Appendix D – Detailed Response to Submissions

Table 1 DPHI Request for Information

Table 2 Agency Submissions

Right: Plan of the bridging solution

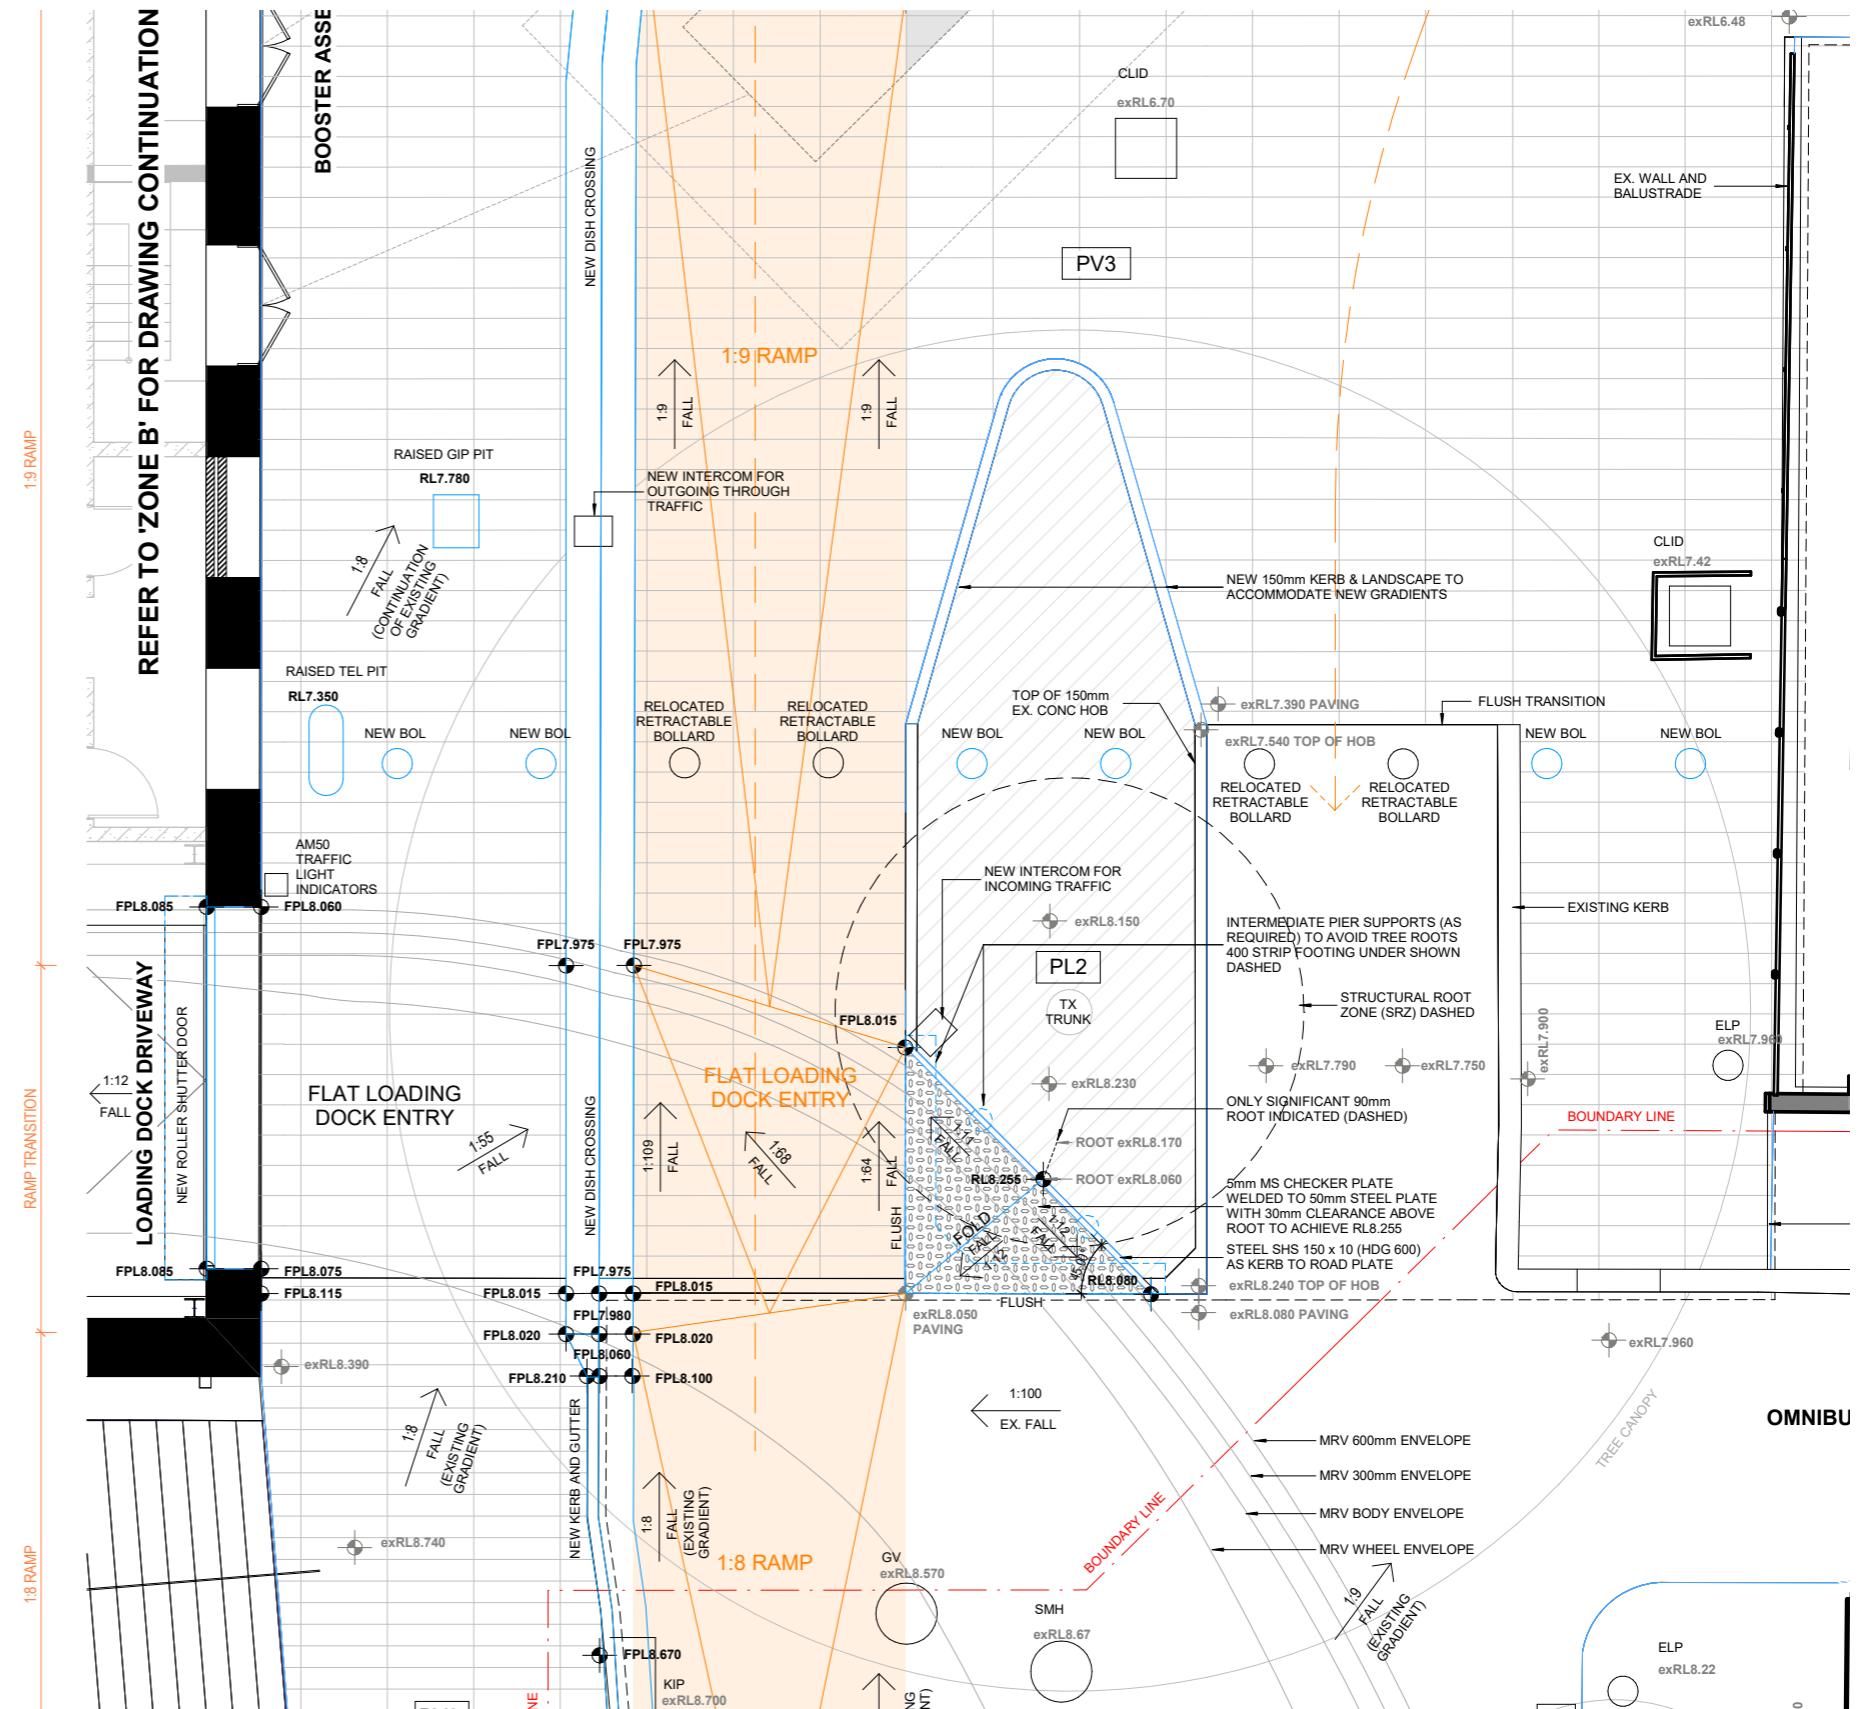
CoS17	<ul style="list-style-type: none"> Trees Proposed for Retention <ul style="list-style-type: none"> A total of 15 trees are proposed for retention, being: <ul style="list-style-type: none"> Tree 17 <i>Platanus x acerifolia</i> is an inroad planting located within the Macarthur Street alignment. Trees 12, 5-15 (12 trees) <i>Platanus x acerifolia</i> located along Harris Street footpath. 	<ul style="list-style-type: none"> Noted.

<p>Tree 16 <i>Tristaniopsis laurina</i> located within Macarthur Street footpath.</p> <ul style="list-style-type: none"> - All trees have been given a value of 'Consider for Retention' except for Tree 16 which has been given 'Consider for Removal' and Tree 17 'Priority for Retention'. The City supports the retention and protection of these trees if possible. 	
CoS18	<ul style="list-style-type: none"> • Tree 17 <i>Platanus x acerifolia</i> Macarthur Street inroad planting <ul style="list-style-type: none"> - Tree 17 <i>Platanus x acerifolia</i> located within the Macarthur Street alignment, on the site, will be subject to a major encroachment due to the proposed demolition and pavement installation within its TPZ. Due to the surrounding road surface and compaction within this area, the AIA report indicates there will unlikely be significant roots within this area. - However, the AIA report has given detail of tree protection requirements and mitigation measures within Section 3.2.9 of the report for the garden bed construction and resurfacing of the new road pavement. This includes the modification of the loading dock entrance outside of the SRZ of Tree 17, modification (extension) of the garden bed to the east and installation of bollards for future trunk protections from vehicle impact damages. - The plans should be amended to reflect design modifications as outlined within Section 3.2.9 of the AIA. 	<ul style="list-style-type: none"> • Noted. • Noted. • A design outlining the measures required to ensure the retention of Tree 17 is provided within the Amended Public Domain and Landscape Statement Appendix Q to this Submissions and Amendments Report.
